PLANNING APPLICATION REF: 2022/62/92406/W - CHIPPINGS SITE, CHAPELGATE, SCHOLDS

Further to my previous comments of 5th September 2022 I wish to register my continued opposition to the above, my additional comments of objection being as follows:

Name	(462)-GWP-01-01-D-A-(PA)-0001		
Scale	1:1250@A3	Revision	P02
Drawn/Checked	CT / RT	First Issue	12.04.22
Drawing Status	S2 - WIP

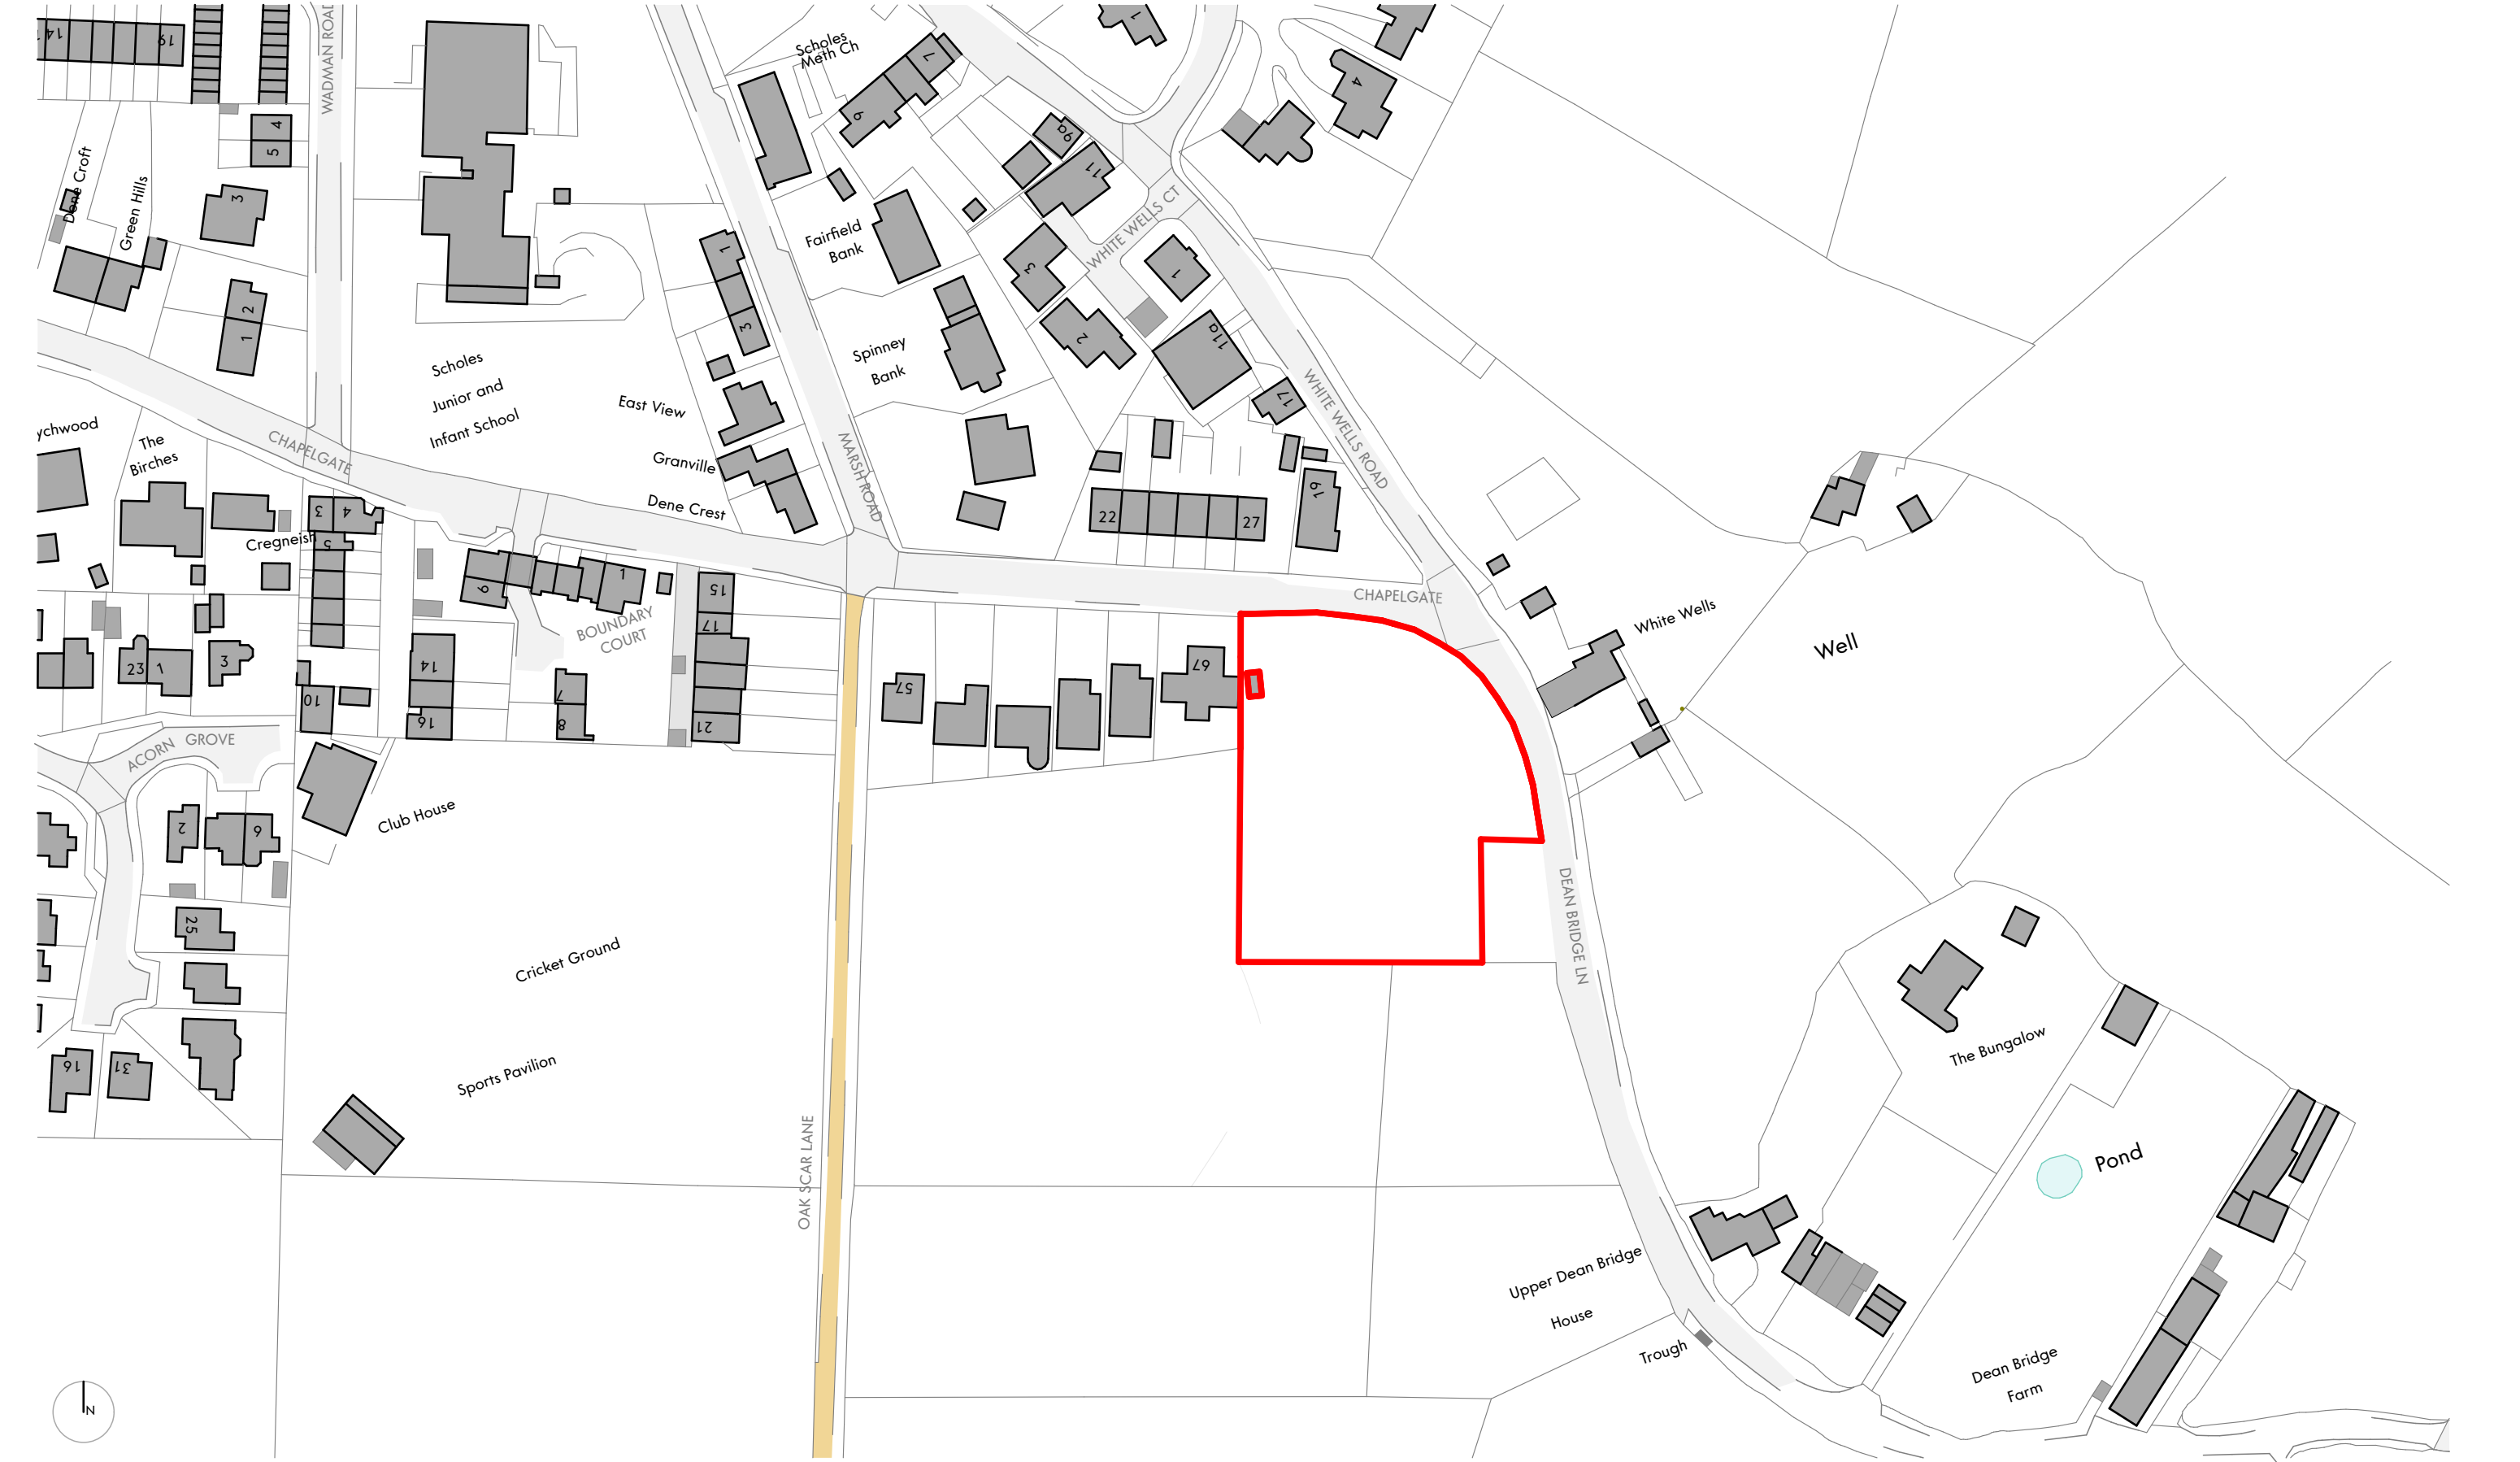
The plans below show what is now the actual edge of the road. You can physically see where pieces of stone have been used at the edge as a face to tarmac up to in the past. Section 44 of the Highways Act 1959, superseded by Section 41 of the Highways Act 1980 places a duty on the local highways authority to maintain the highway. A lack of maintenance has resulted in the verge encroaching onto the highway over the years. Consequently, the visibility splays shown on the Applicants block plan cannot meet the requirements of the Highways Design guide as the Applicant has relied on the line of the overgrown verge being the road in order to achieve the visibility splays shown. The copy of the block plan below shows what the visibility splays actually are. The larger scale plans show the LH splay being 23m and the RH splay being 16m subject to possible change.

It should be noted that the left-hand visibility splay cannot be altered. These visibility splays do not meet with the requirements of the Highways Design Guide.

The Applicant is including part of the highway as the site development boundary. This is to include the areas of road required for the visibility splays shown, which are required to accommodate the site access road. If these areas of road are going to be utilised for footpaths then this will effectively reduce the width of the road, on a bend and at the junction of White Wells Road/Chapelgate/Dean Bridge Lane. Absolutely preposterous and I can't understand how Highways have agreed to this. The left turn from Chapelgate into White Wells Road is a difficult manoeuvre as it is, especially for the local H1 bus service as they use the full width of the road, and the plan is to narrow it here? The road cannot be reduced in width in any case as Section 76 (1)(2) of the Highways Act 1959 which relates to 'variations of widths of carriageways and footways' only applies to a highway which has a footpath attached, the implication being that the main highway cannot be reduced in width.

HIGHWAYS – the visibility splays shown are incorrect as the Applicant has based them on the incorrect line (edge) of the road together with parts of the highway to provide visibility splays needed to meet the requirements of the Highways Design Guide. The revised visibility splays shown using the correct line of road edge **do not conform** with these requirements.
